From: Paul Cann
Sent: 19 June 2013 14:20
To: Planning.Responses
Subject: RE: Planning Consultation on: A/74/13/

Engineers comments in respect to surface water drainage:

Site Address: The Vinery Poling BN18 9PY

Description of Works: Proposed distribution warehouse and covered storage, trade counter and associated offices. Upgrading of access road for and improvement of existing junction with the A27. This application is a Departure from the Development Plan and affects a public Right of Way.

PROPOSED SITE PLAN

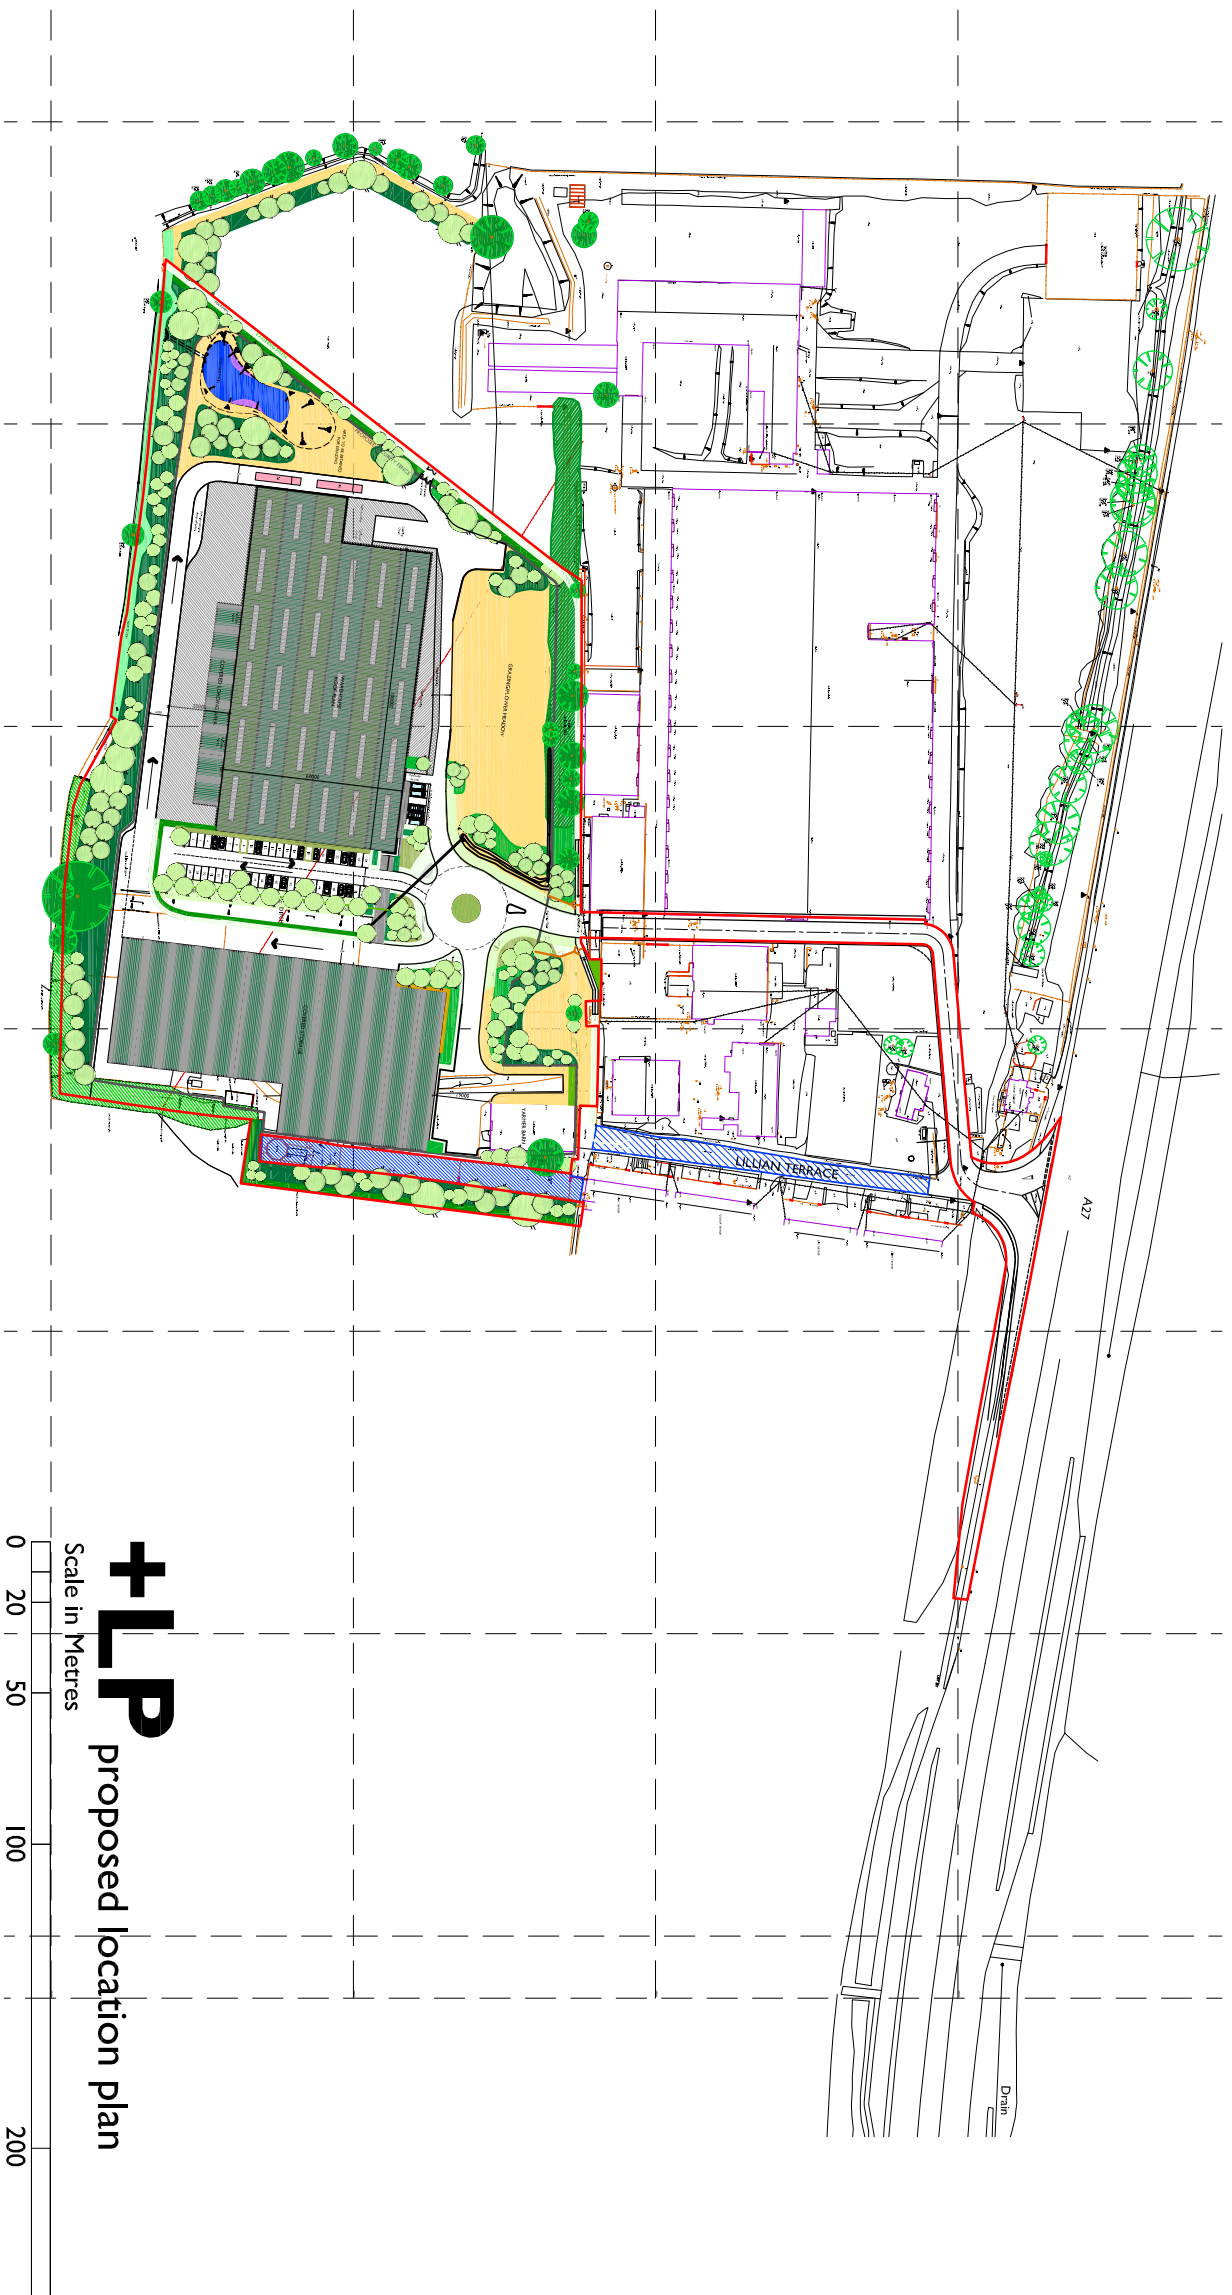
Existing watercourses cross and abut the development site. Agreement/consent will be required for any culverting of existing ditches. The condition of the existing ditches will also need to be accessed in order to determine if maintenance/improvements are required.
